28/11/2019

**New Marsden Park Public School (SSD-9809)
Response to Submissions**

SCHEDULE 1 – KEY ISSUES

Drawing Title
SITE PLAN - TEMPORARY SCHOOL LAYOUT

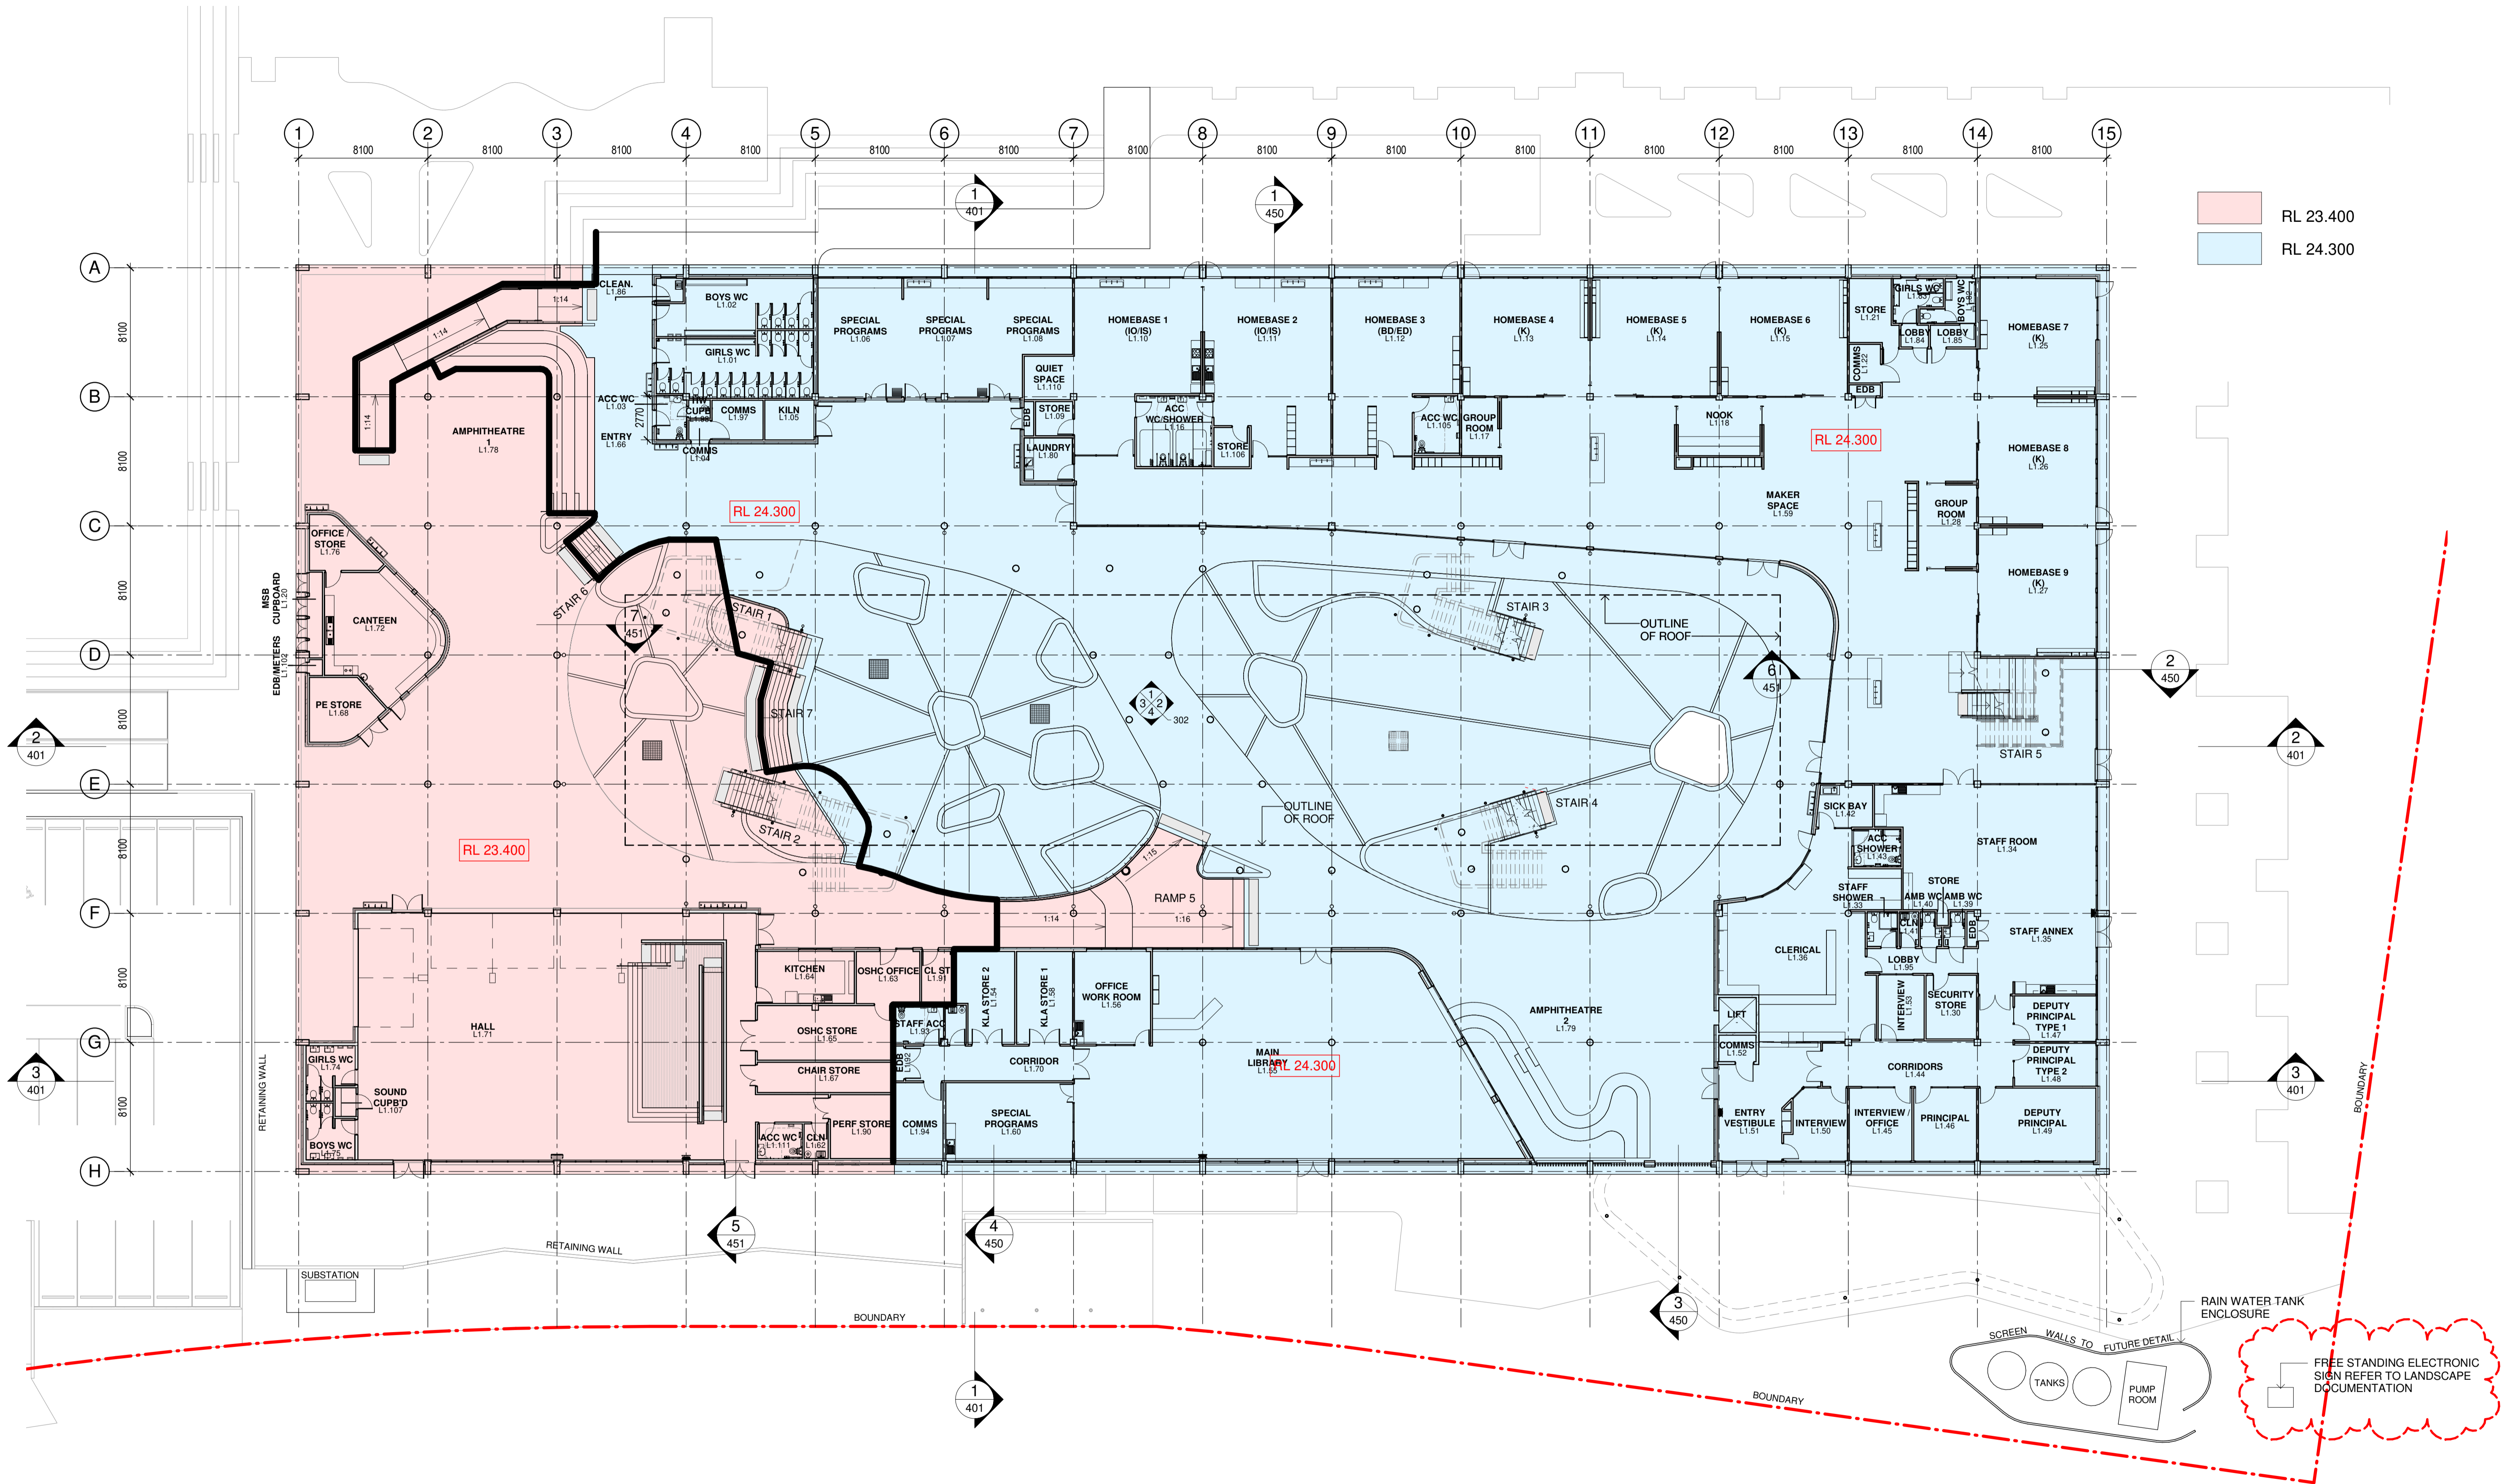
- Provide a stormwater management design and plan for the temporary school scenario.
- Provide a review and redesign of the proposed stormwater plan, including onsite stormwater detention basins, in line with Blacktown Council's Water Sensitive Urban Design requirements.
- Provide a revised flood impact assessment undertaken by an engineering consultancy specialising in flood modelling to address floodplain risk management aspects, as detailed by the Department's Environment Energy and Science Group.
